From: Andrew Fuller [REDACTED]
Sent: 06 September 2017 13:27
To: Anita Gardner
Cc: Estella Wood; Ian Wightman
Subject: Ancton Manor M/31/17/HH

Following consultations with both Ian Wightman and Green Oak Carpentry Co (the frame manufacturers), I now attach our amended drawing for the above application, 26905/02A. This is a substitute for 02.

Job Title			
Client	Ancton Manor		
	Dr Heather Beaumont		
Drawing Name	Plans & Elevations Proposed		
Drawing Status	Planning		
Drawn by	AF	Date	Mach 17
Checked by		Date	
Drawing Scale	1:100 at A2		
Drawing No	16905/ 02	Status	Revision
			A

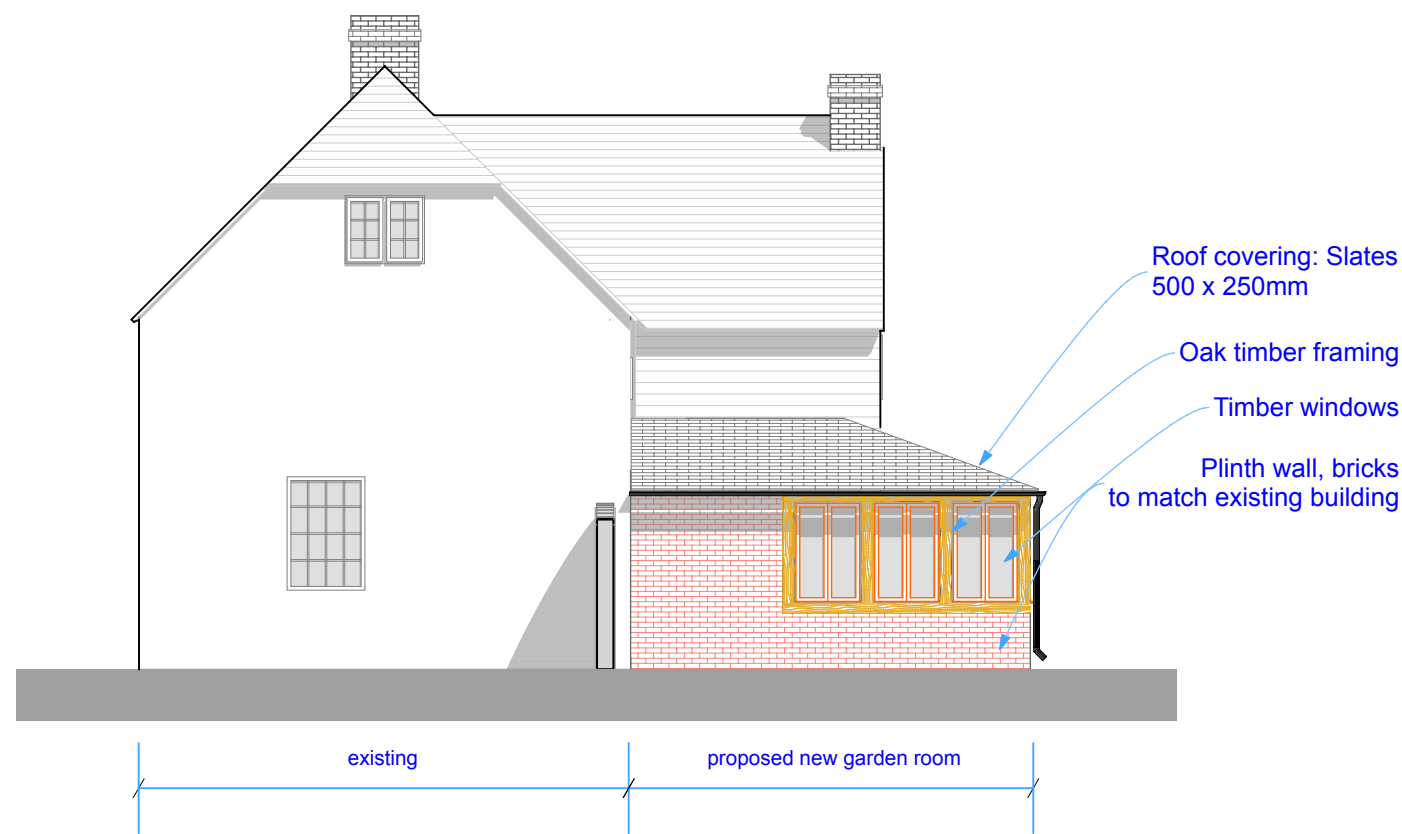
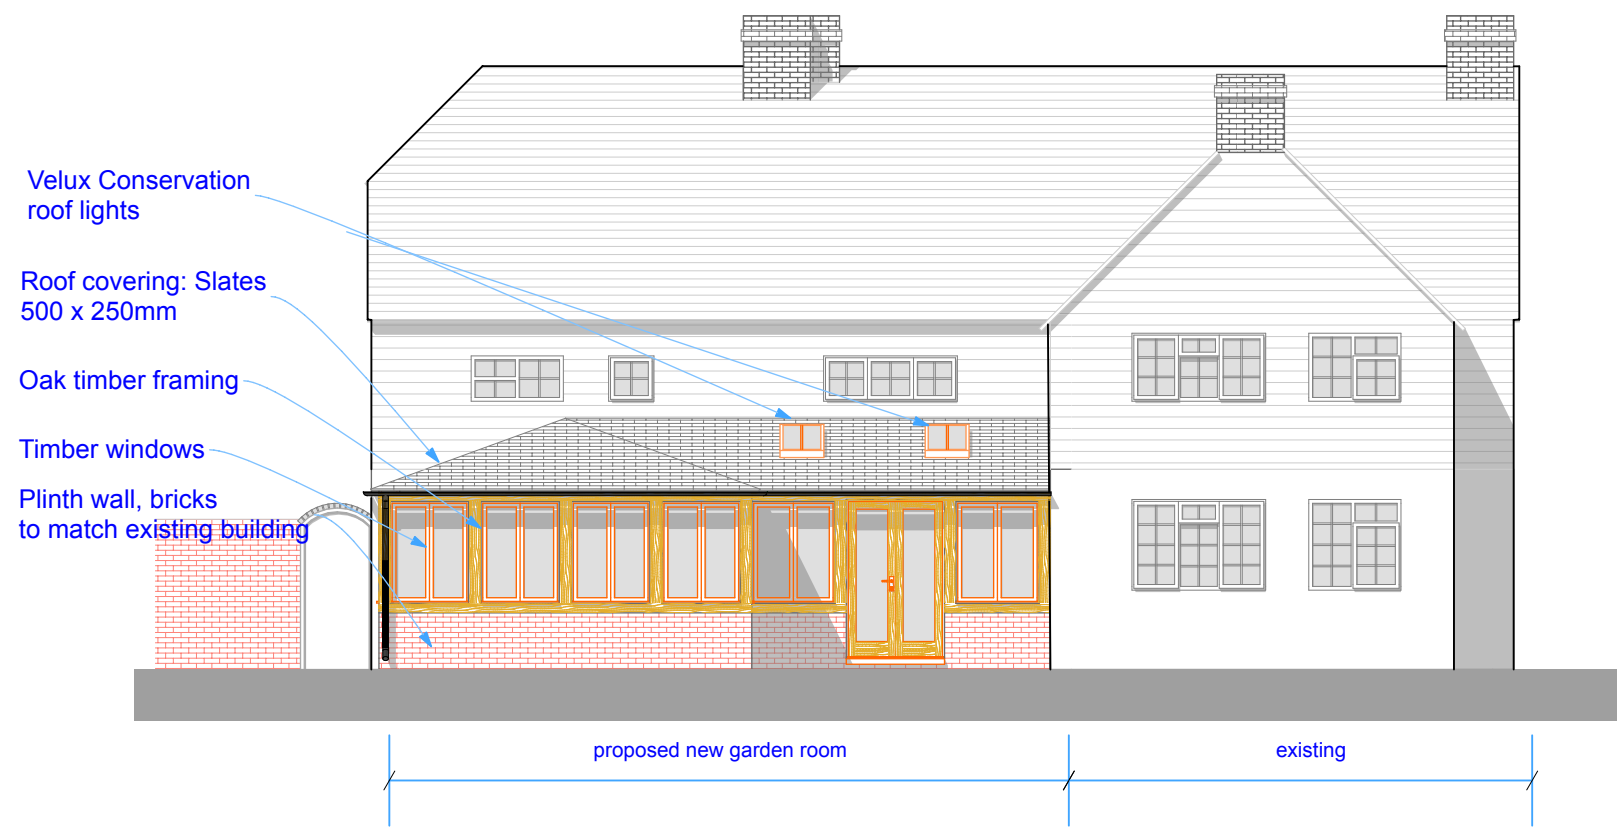
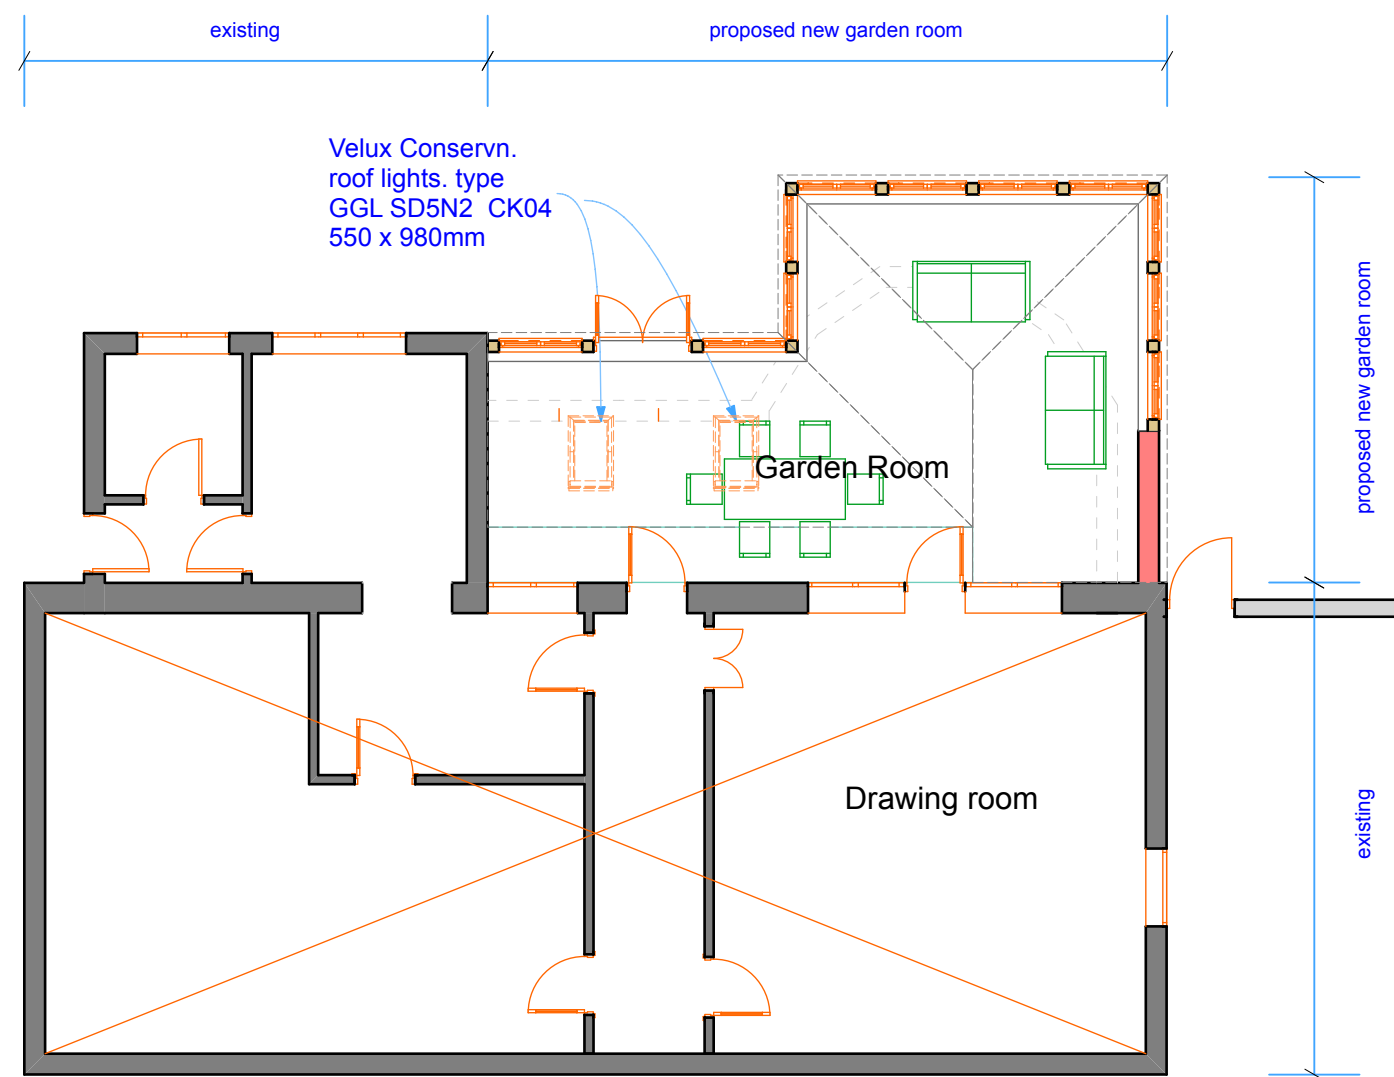
1. Changes the roof to a complete shallow pitched, slated roof of 20°.
2. Replaces the Lantern window with Conservation skylights.
3. Lighten the timber frame thicknesses slightly, in order to make the frame not too dominating externally. I await exact reduced timber sizes from Green Oak CC, and will be happy to provide these in due course.
